Application No: 320120129P

From: Louise Blatchford
To: graham.1.wood@btconnect.com
Cc: Lesley Lund
Sent: Monday, February 13, 2012 4:44 PM
Subject: Planning application - Whalley Telephone Exchange, Station Road, Whalley

RE: Remove glazing from 2no. ground floor window frames and install 2no. steel cowls painted to match building

AT: Whalley Telephone Exchange, Station Road, Whalley

WBS7964

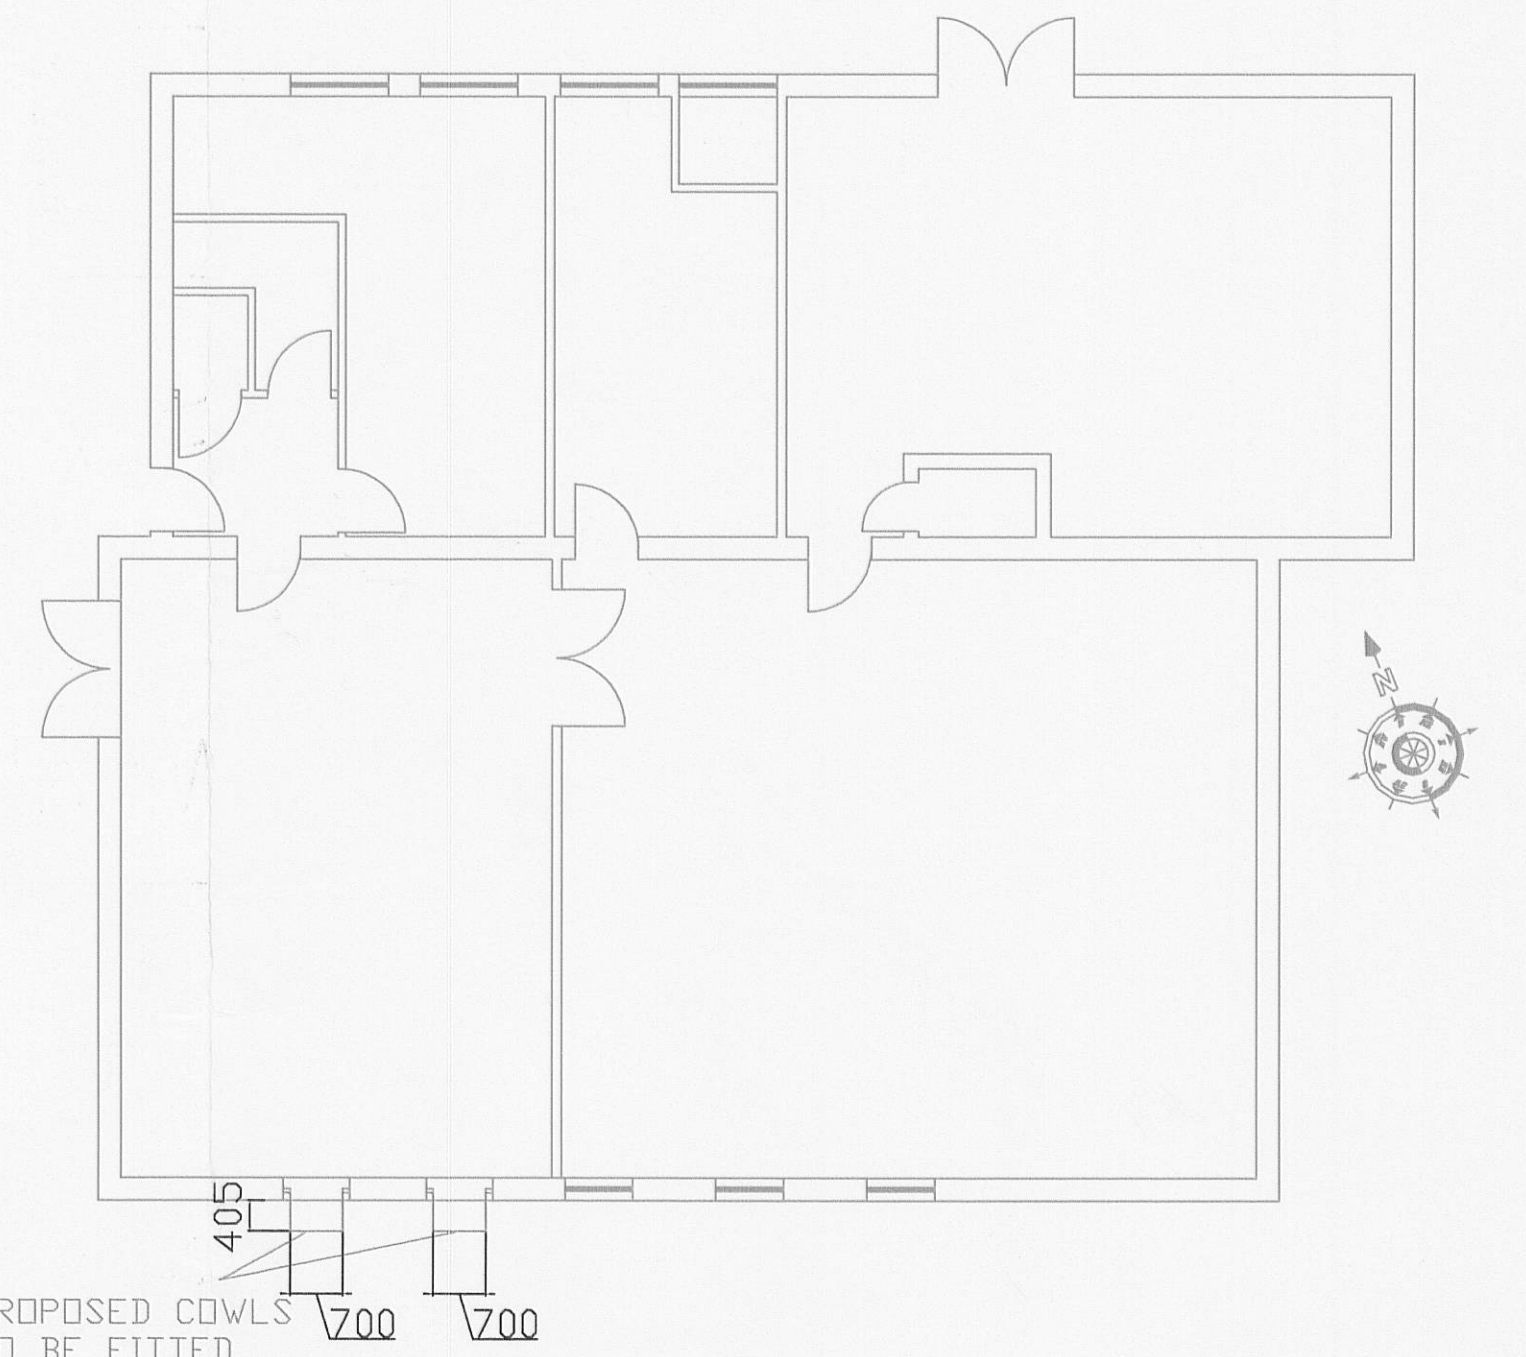
- We appreciate that the plans are drawn to scale but we do require all proposals to be annotated with dimensions. Please can you mark on the overall external dimensions (in metric) of the proposed cowls to show their length and width.

- Finally, please can you provide the existing and proposed elevations for both side elevations of the telephone exchange. This is so that the planning officer can fully assess the proposal and see the projection of the cowls from both sides of the building. (Please can you label the elevations east and west). This needs to be drawn to a recognised metric scale and again please can you mark on the overall external dimension of the cowls to show their projection.
